**WRITTEN REPRESENTATION SUBMISSION BY**  
**NATIONAL HIGHWAYS**

**Reference:** TR050007

**Proposal:** Application by Tritax Symmetry (Hinckley) Limited for an Order Granting Development Consent for the Hinckley National Rail Freight Interchange

**Date:** 23 October 2023

**M69-A47 LINK ROAD GENERAL ARRANGEMENT**

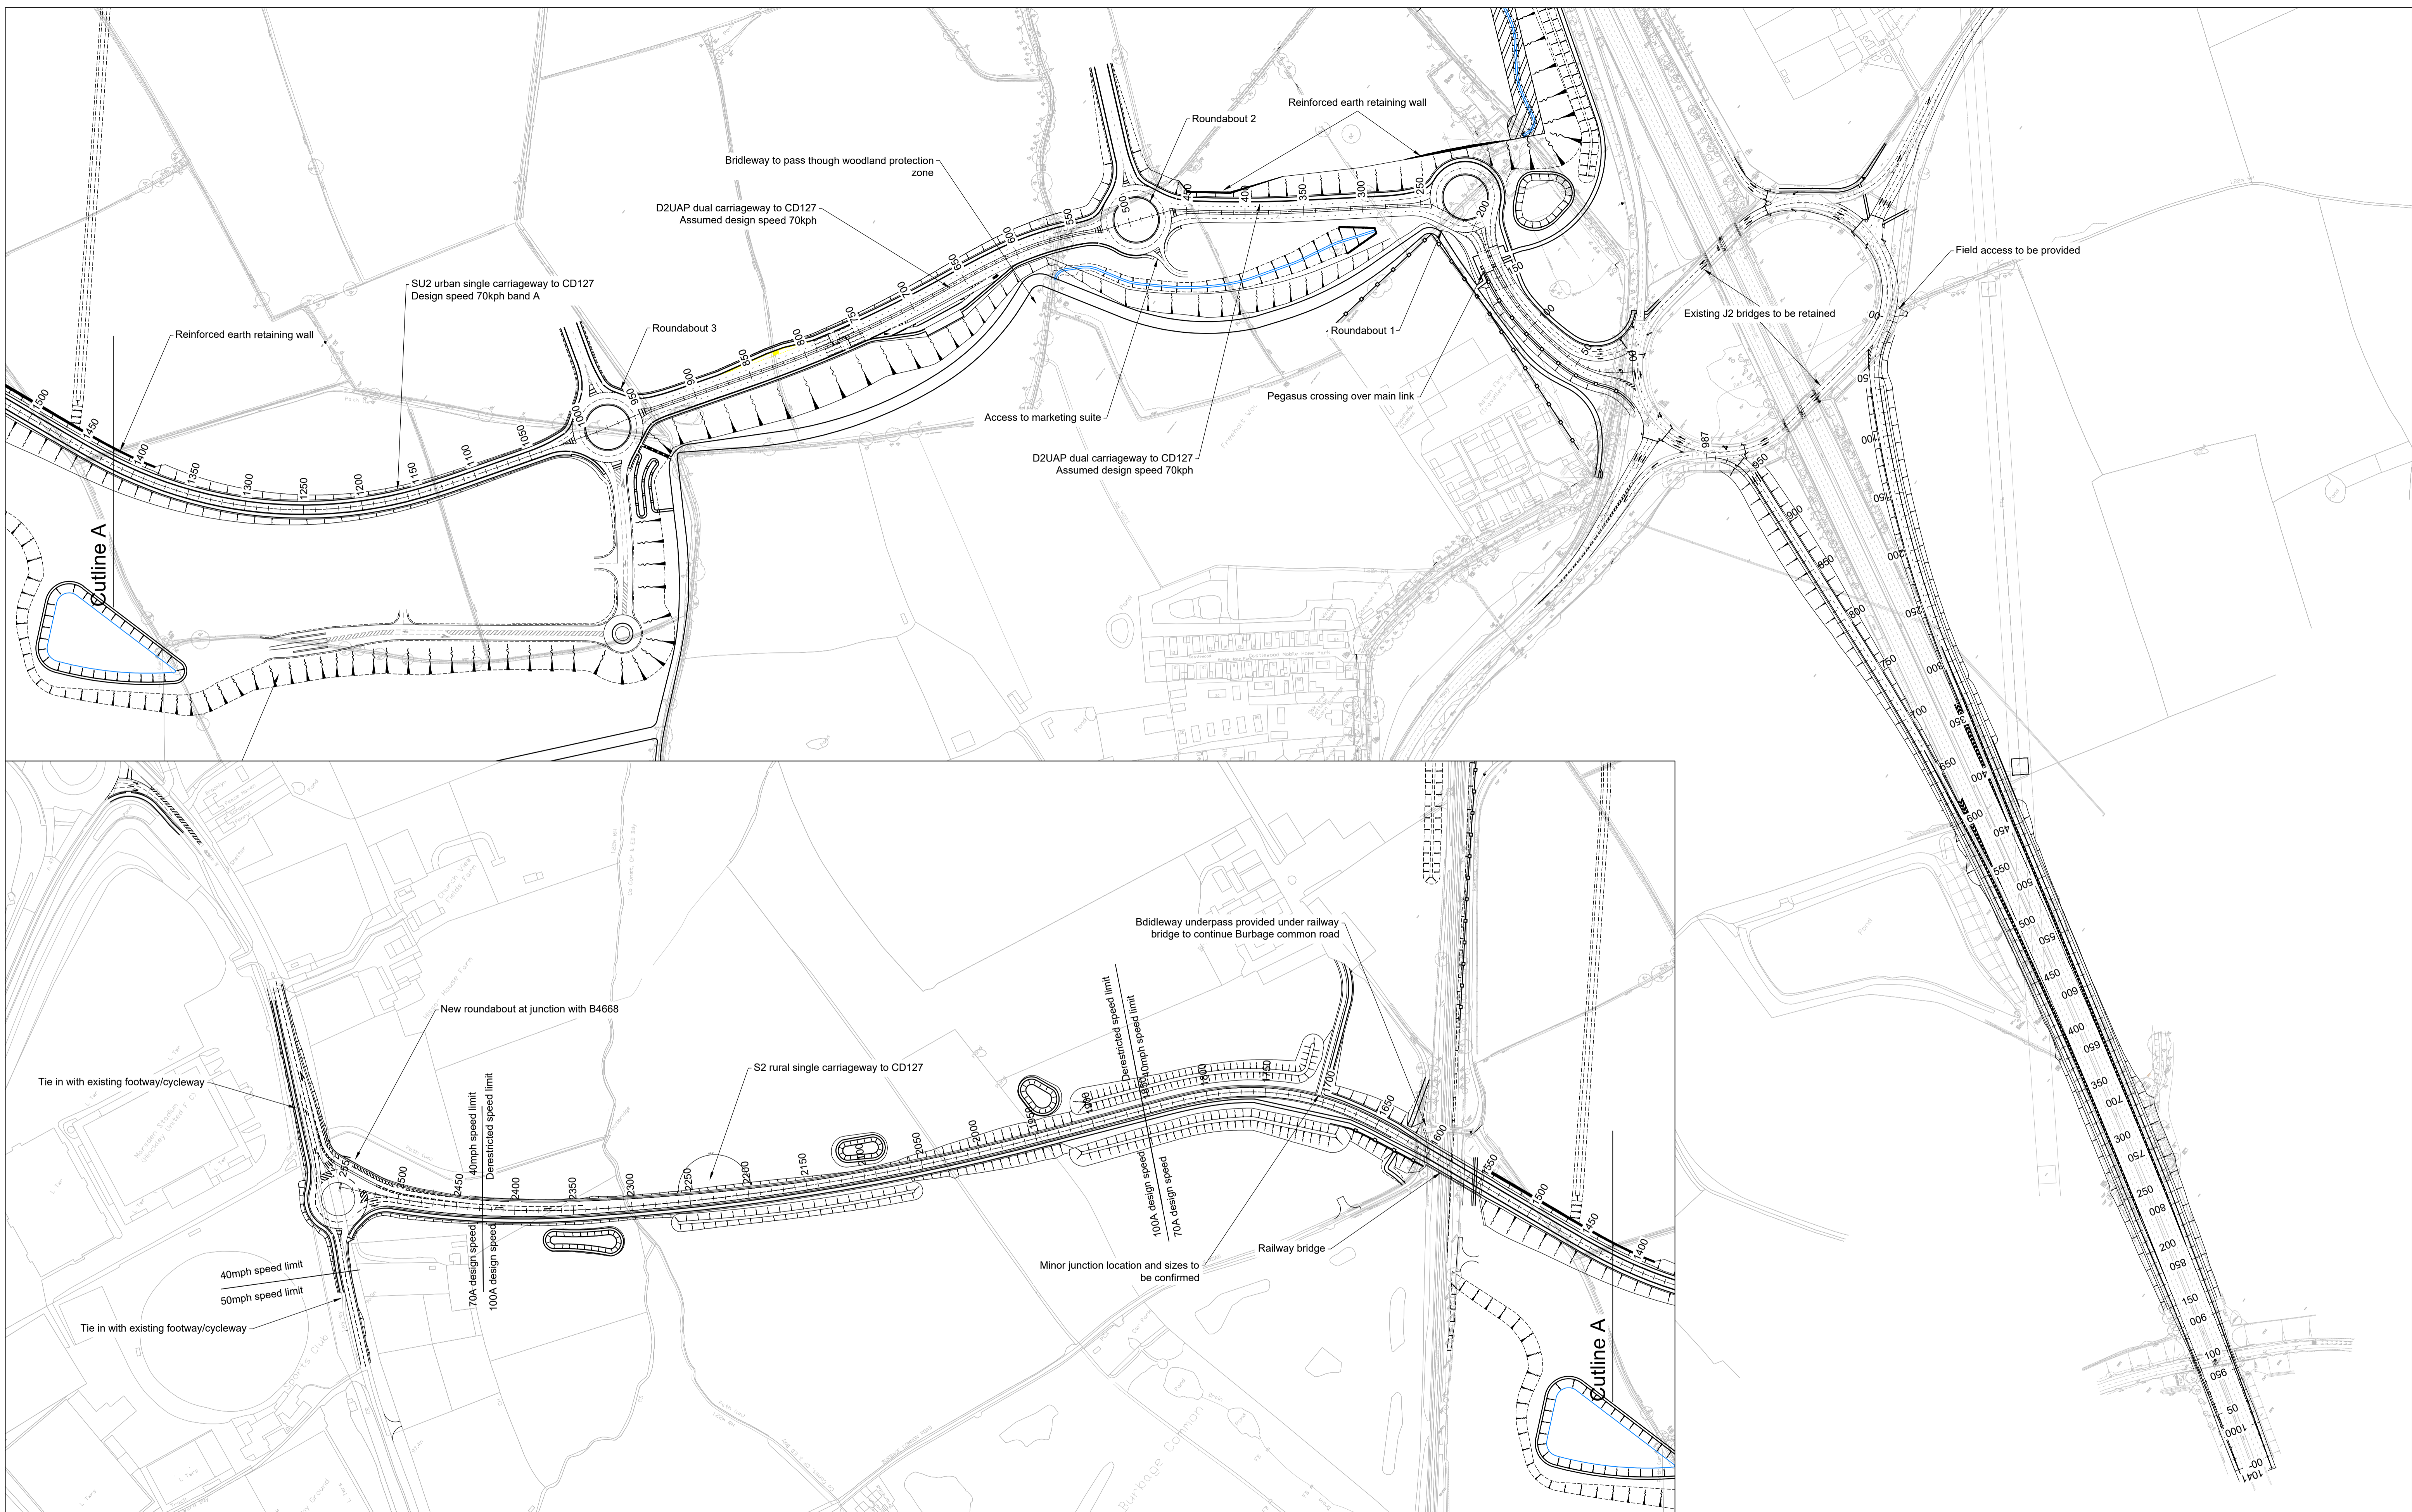
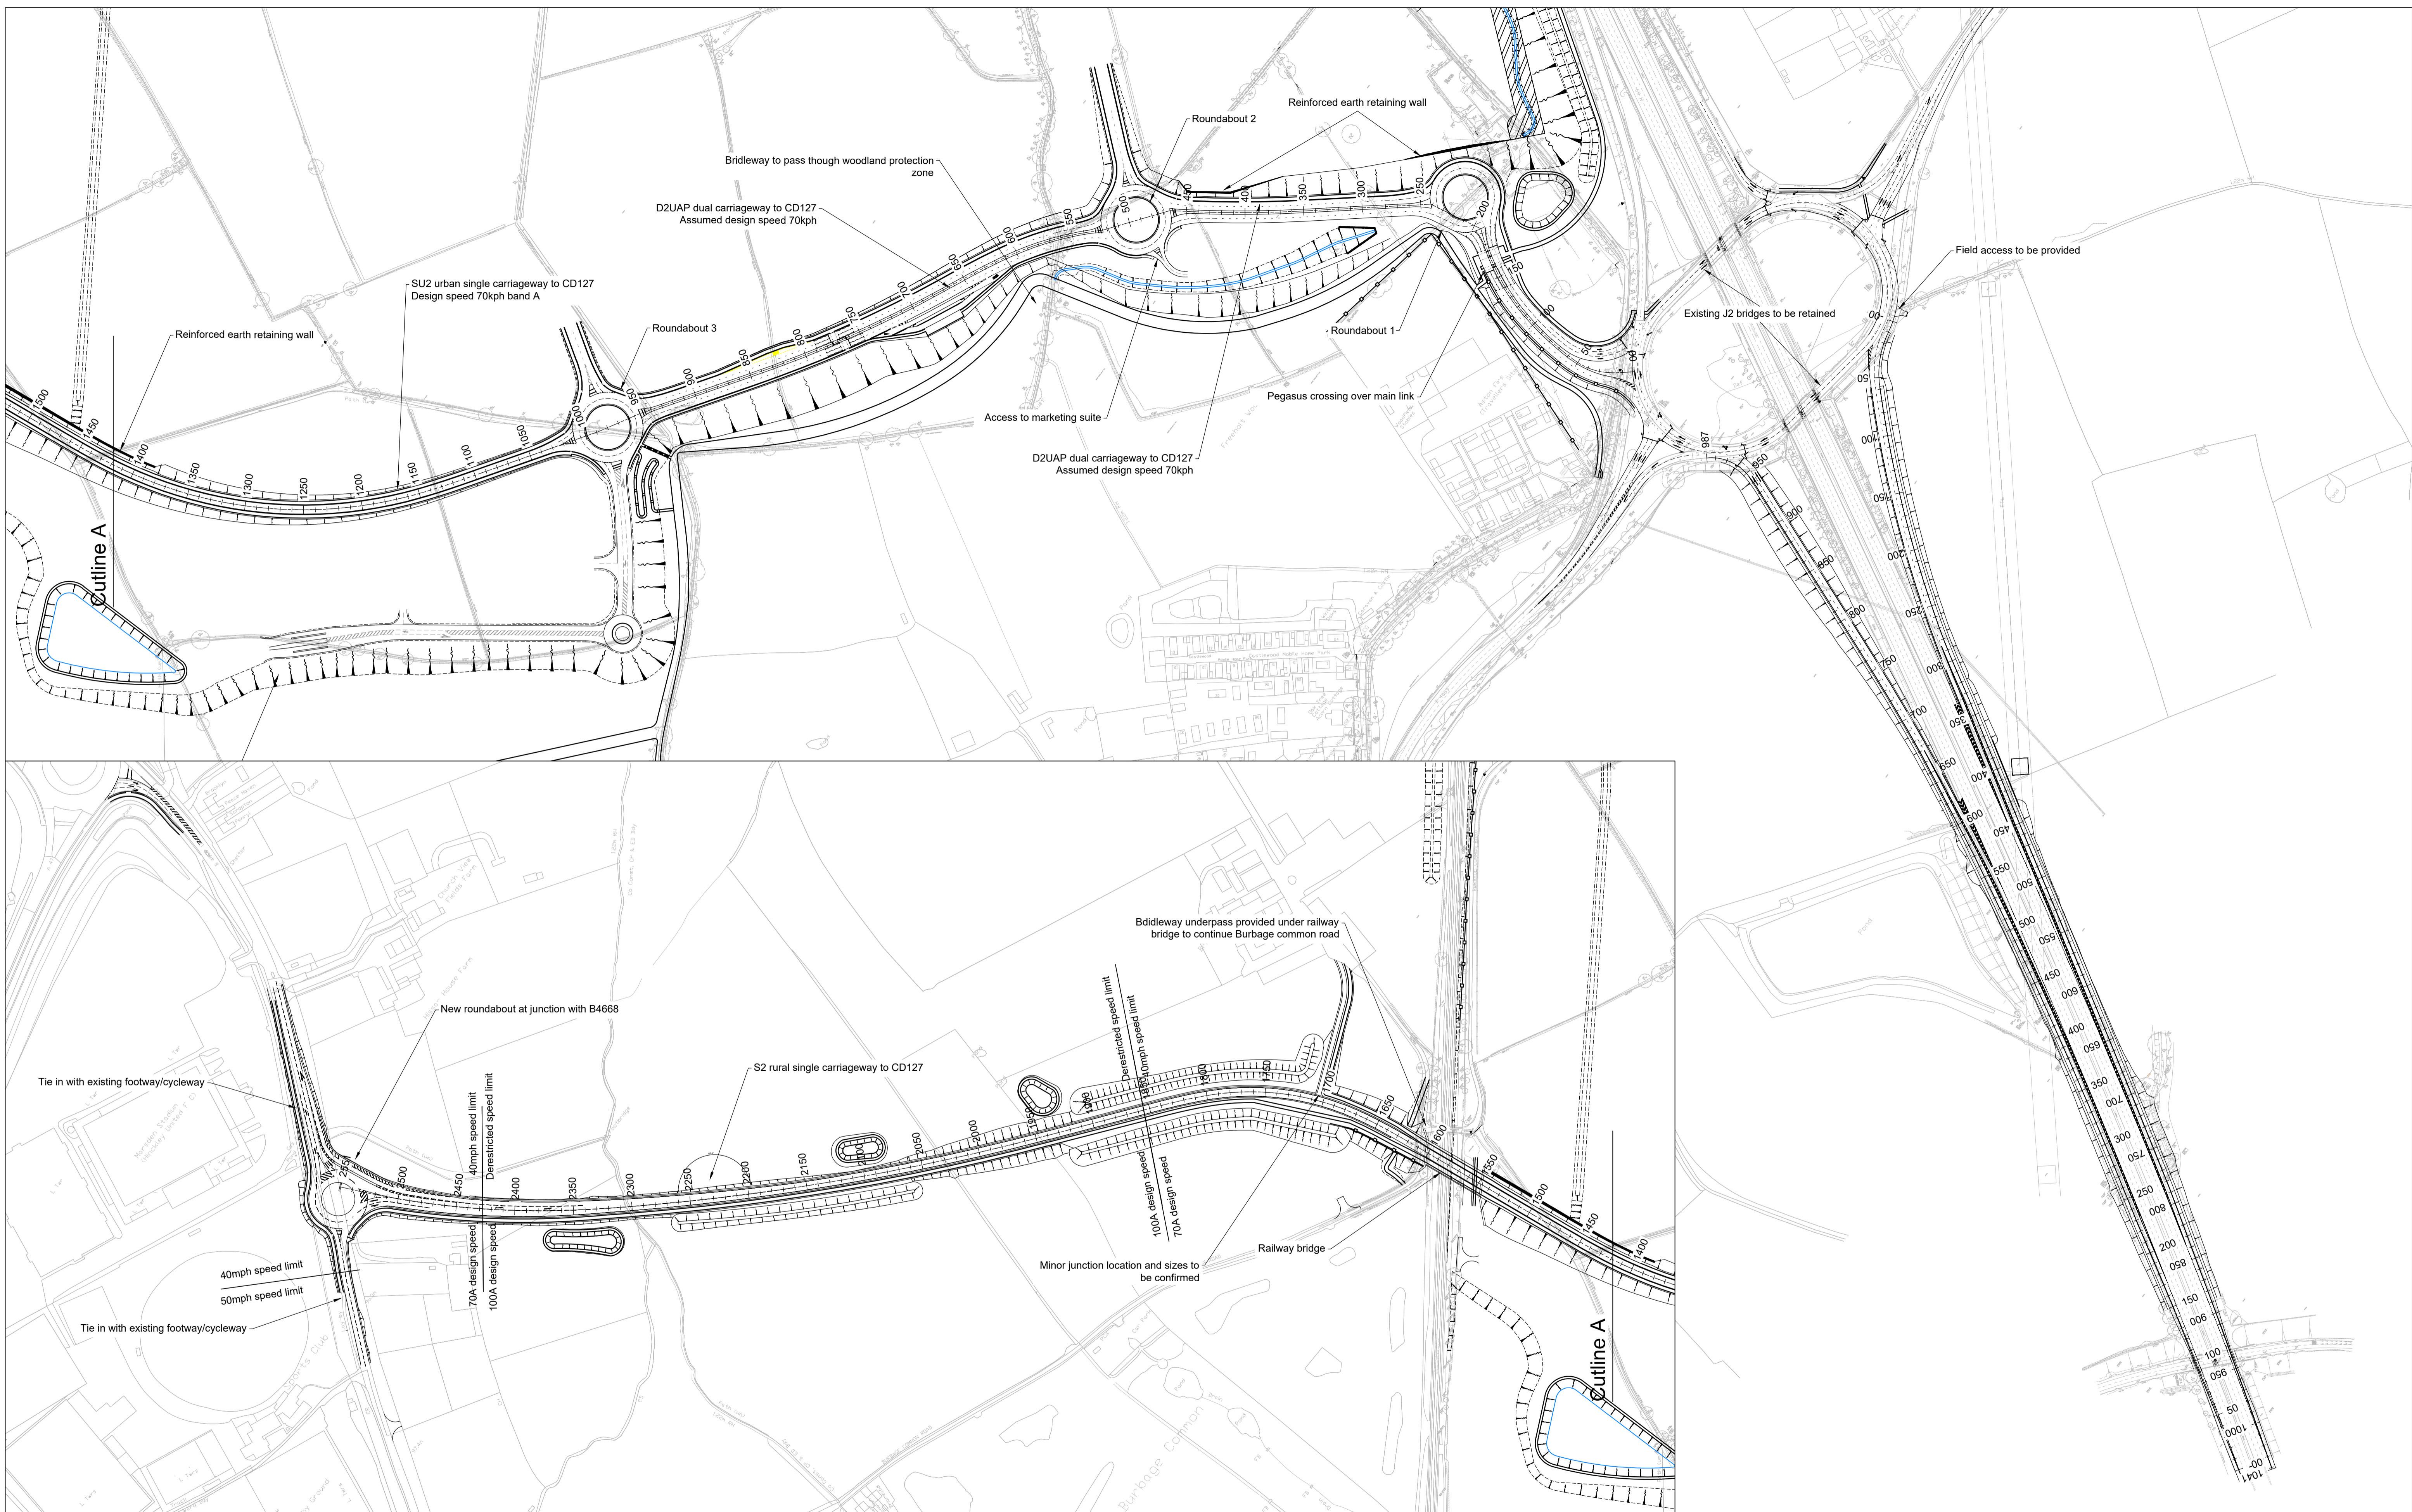
- e. National Highways have not been able to agree the design or deliverability of the access arrangements onto M69 Junction 2 due to the outstanding strategic modelling.

- f. National Highways have not been able to agree the design or deliverability of the northbound off-slip and southbound on-slip at M69 Junction 2 due to the outstanding strategic modelling.
